Review Response

Date: 06/06/2024
Project Name: Wellmon
Response To: SHL23-054 SUB 2

This letter is in response to the corrections for SHL23-054. Below are our responses to the questions/comments from May 28th 2024.

# PIER DETAILS - PROPOSED PLAN VIEW

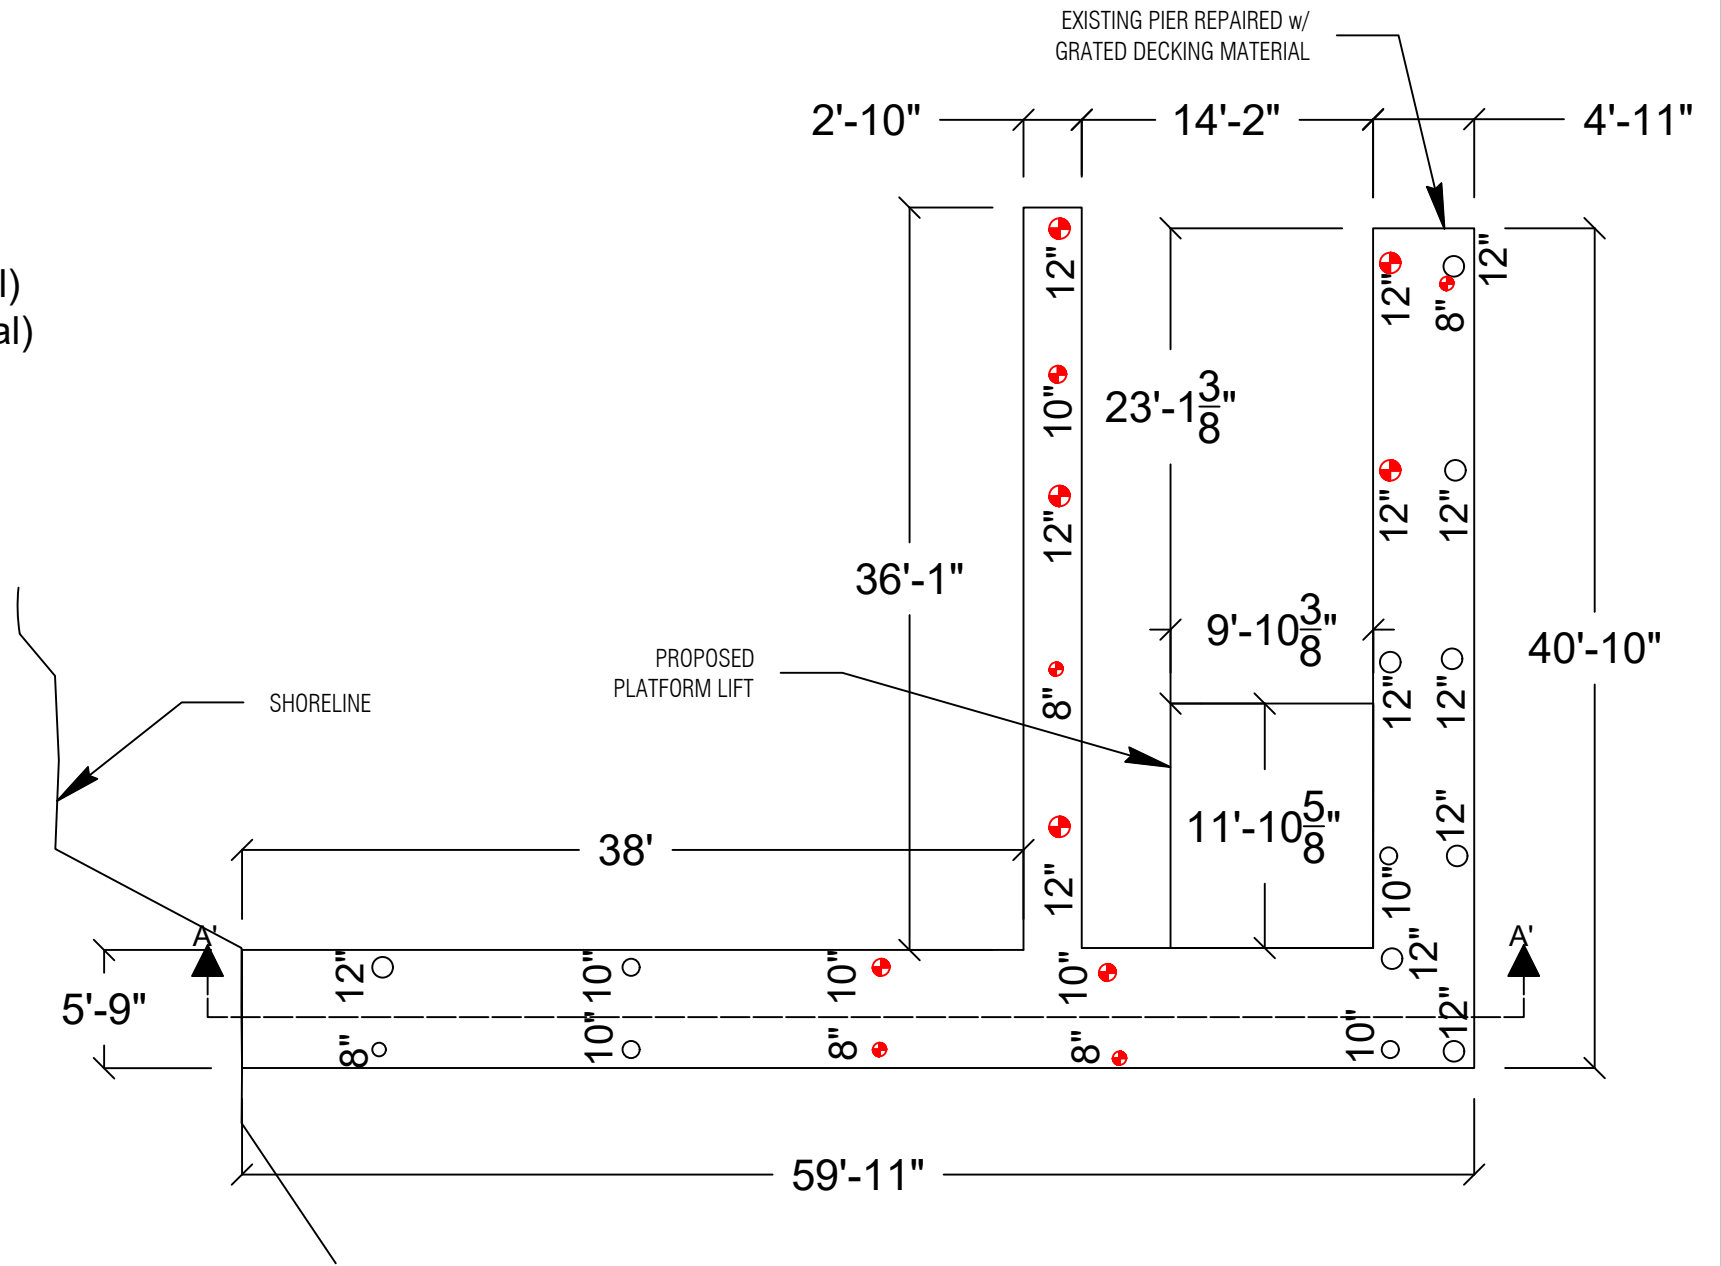
1. Planning:
 - a. The plan has been revised to maintain the existing dock width at 5'-9".
